COMMENTS ON THE APPLICANT'S DEADLINE 6 SUBMISSIONS

DEADLINE 7

IP Ref: 20018303

**A63 Castle Street Improvement Scheme
HULL
TR010016**

High Street Underpass

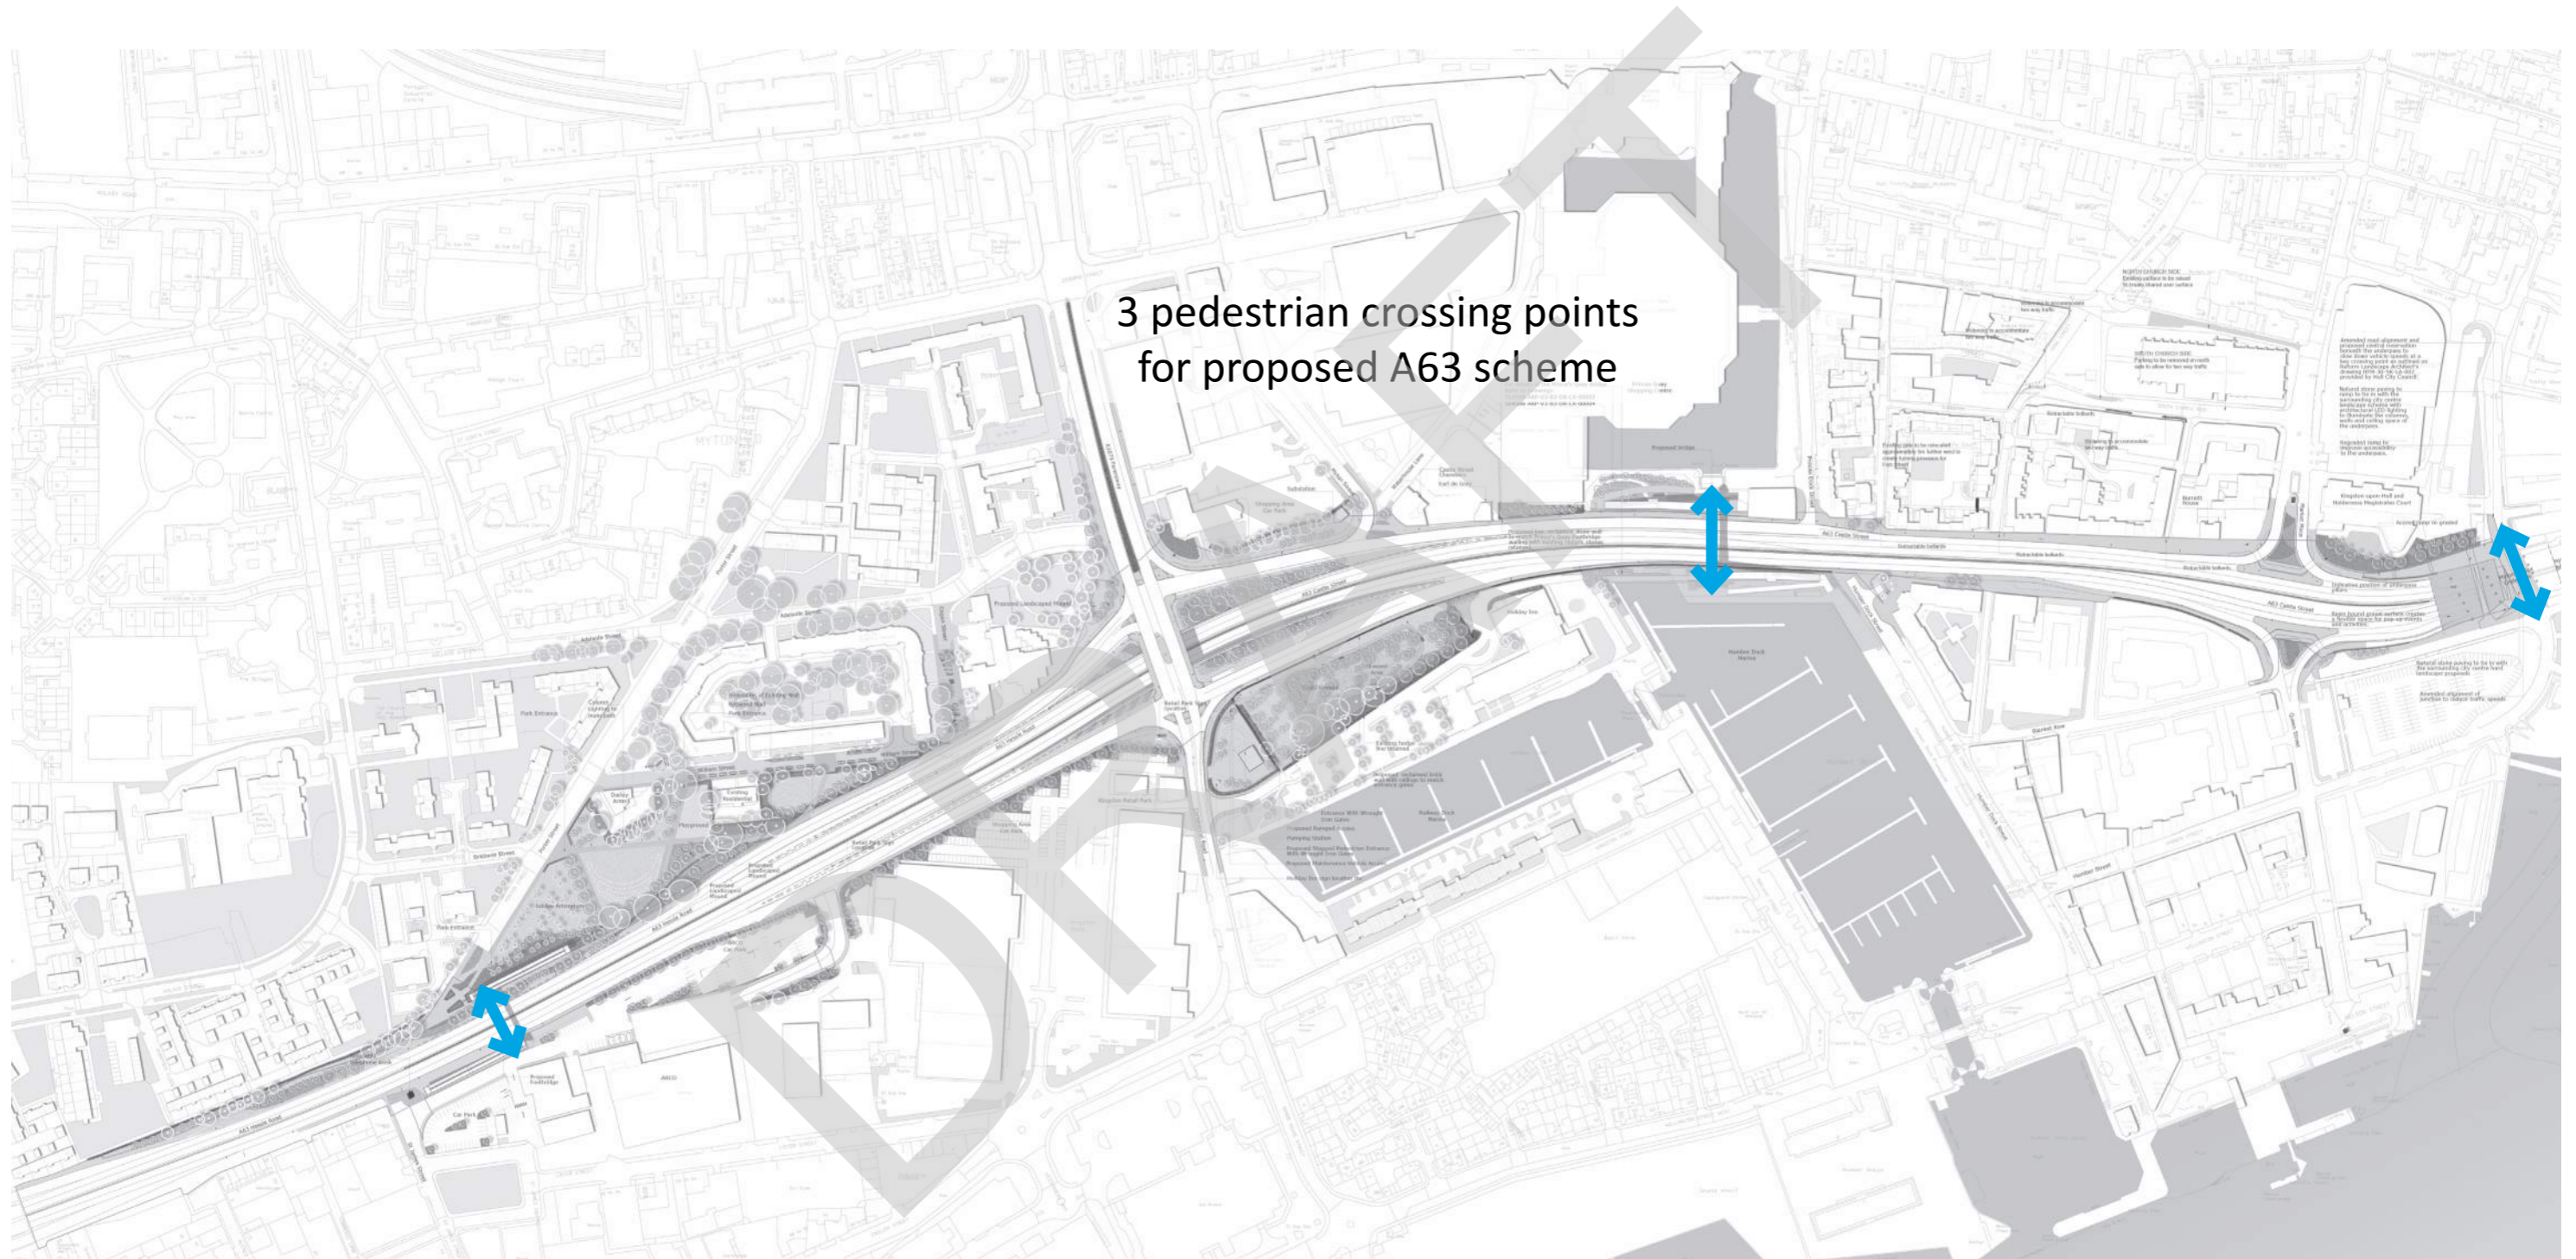
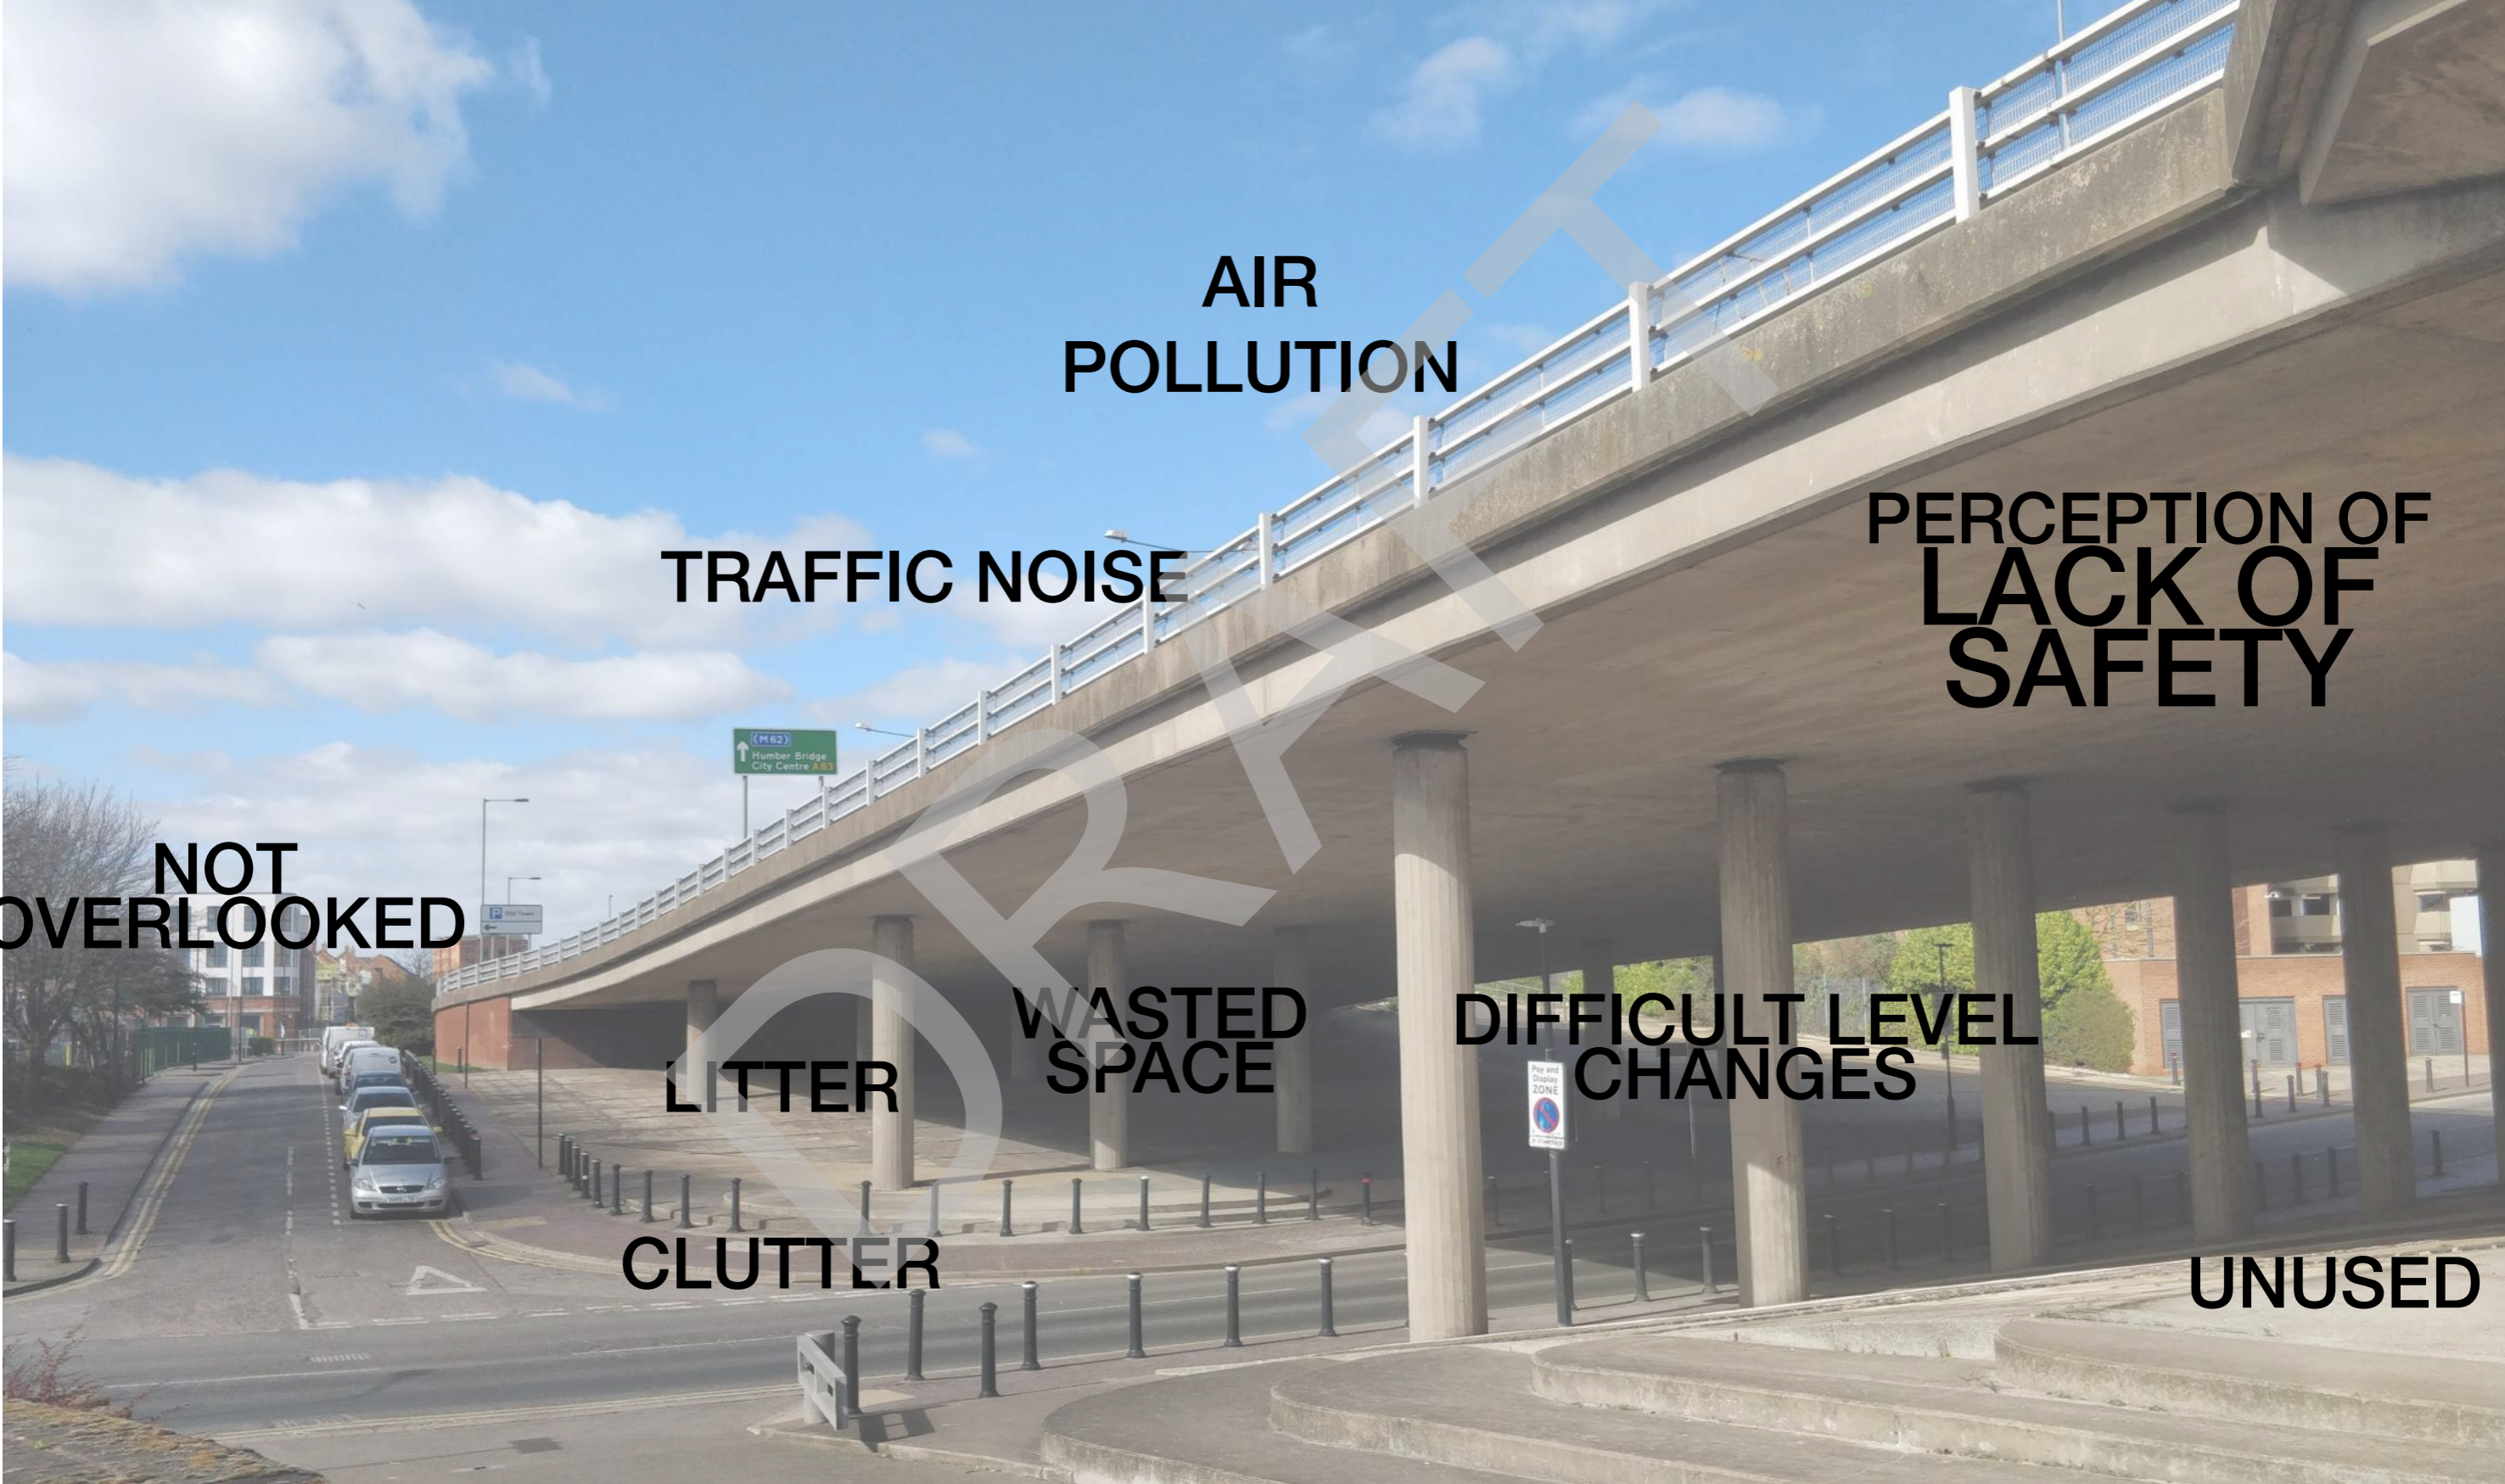
Whilst the indicated lighting proposals do include the area of the underpass to the east of High Street, this does not appear to be included in the other elements, such as the surfacing materials and footway improvements. HCC seek a comprehensive improvement to the full area of the underpass, as this sits within the red line boundary and without will generate a miss-match of quality in environment and materials, and encourage unnecessary pedestrian movements across the highway.
